19 December 2016

Re: 6/2016/2504/HOUSE and 6/2016/2514/EM  
7 Densley Close, Welwyn Garden City, AL8 7JX

Drawing Title: PLANS AND ELEVATIONS  
 AS PROPOSED

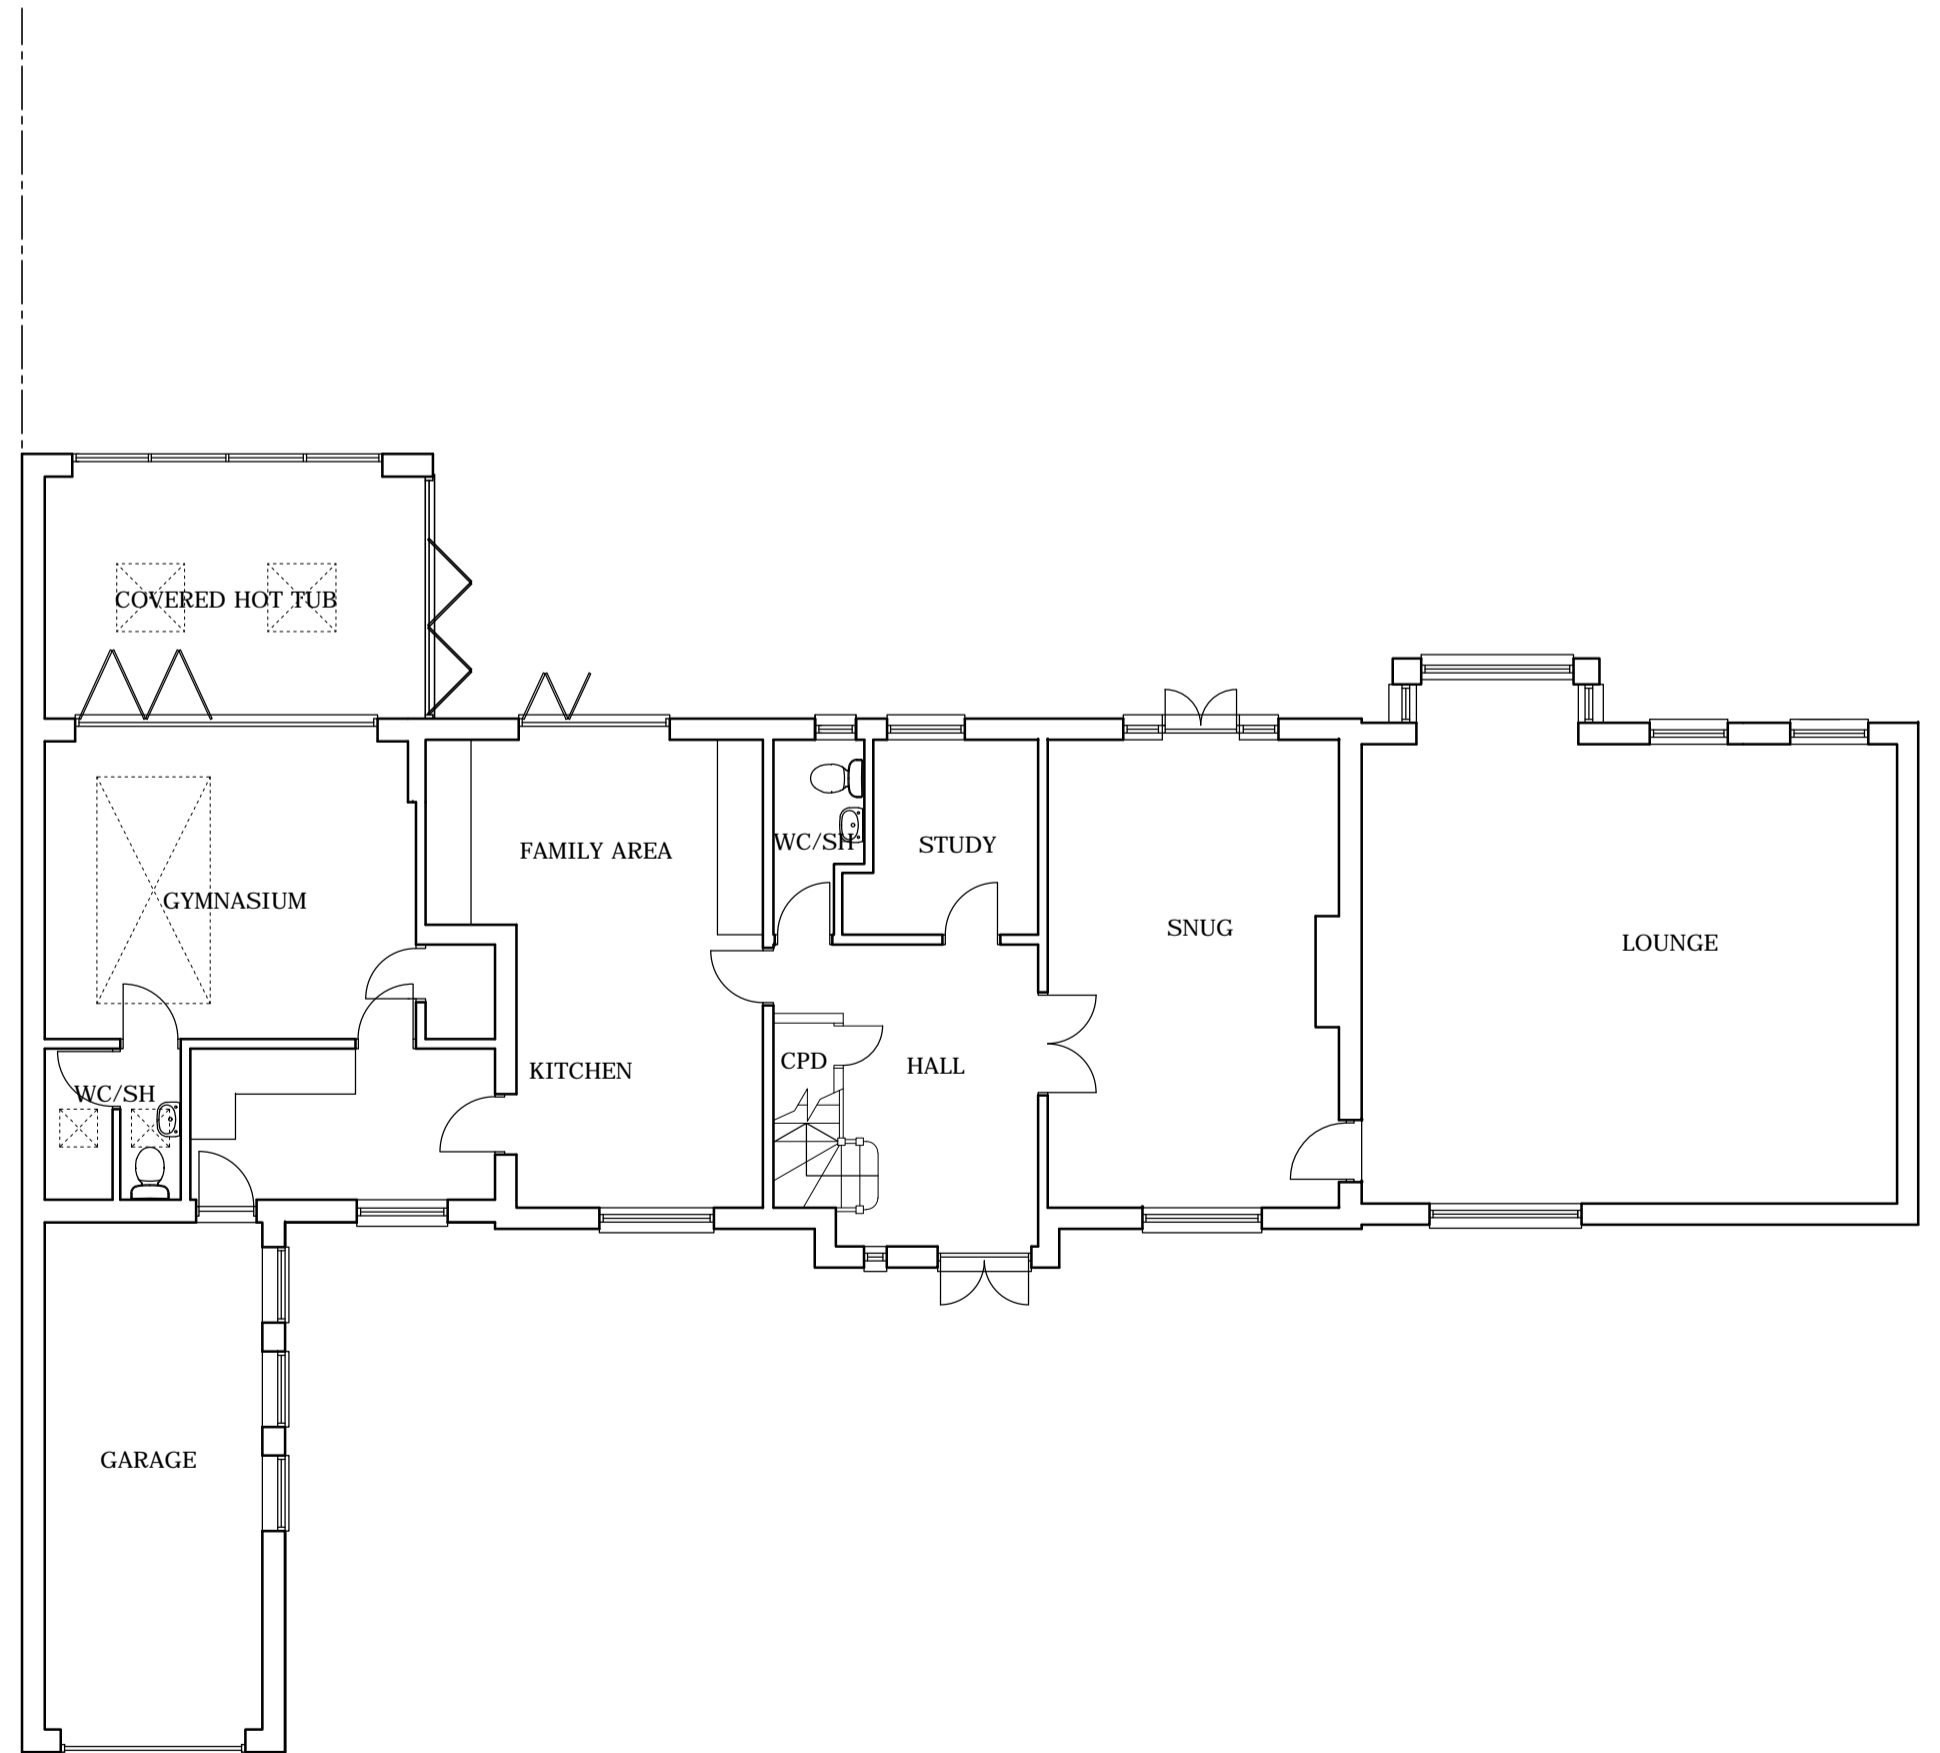
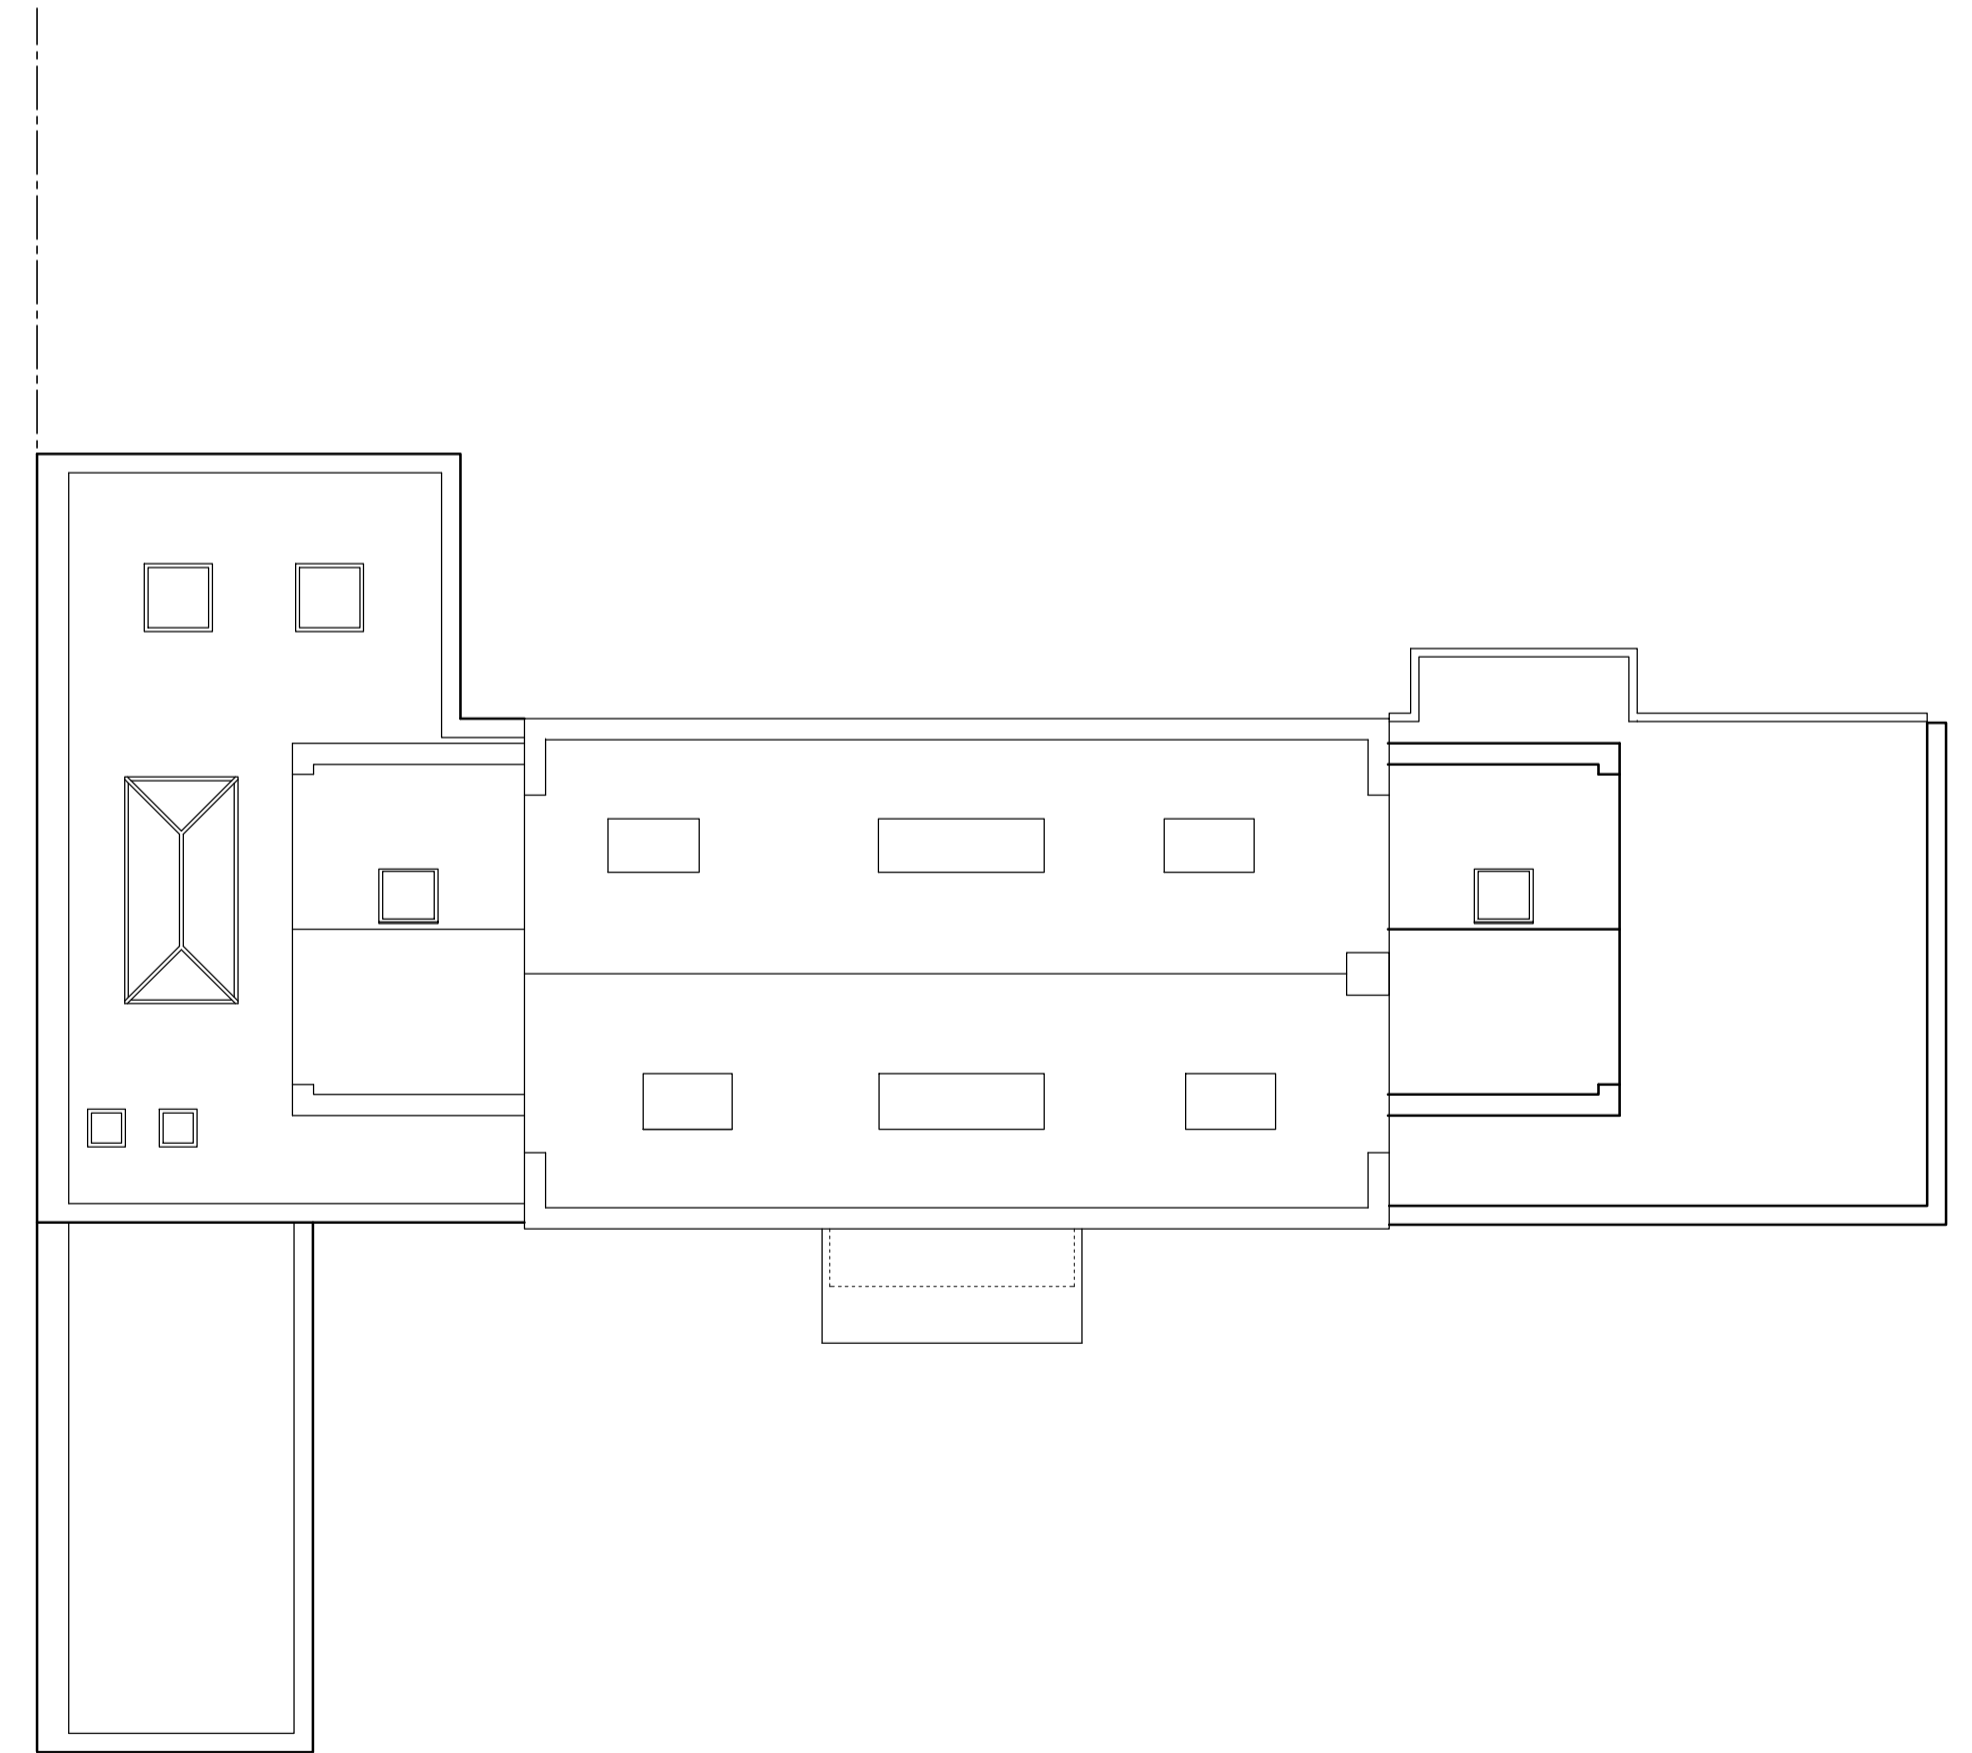
1. We will look directly into the room that Ilett is applying to enclose with bi-fold doors, from 3 upstairs rooms in our house. Please see photo attached. At present we overlook the whole of Ilett's back garden but cannot see into his house. This planning application, if granted, will result in us being able to look directly into his house, which we do not want.

3. The room was a log store/smoking shelter before planning permission was granted for rebuilding it. It had a felt roof and brickwork to 2 sides and was supported by a metal pole at one corner. What has been built in its place is larger than the plans allow for.

4. At no time prior to the present application, did Ilett communicate his intention that the room be enclosed. He has waited until it is built before putting in another application, making it look as though he is merely wanting to enclose the existing open space with bi-fold doors. This was never the intention when planning permission was granted previously.

5. The effect of what he wants to do will be to add an additional room to the property. The house is already over-developed.
6. If Ilett is allowed to close in the old wood store, the area between the garage doors at the front of the property and the additional room at the rear of the property could then be used as a self contained flat. This is not desirable as the property should only be used as a single dwellinghouse.
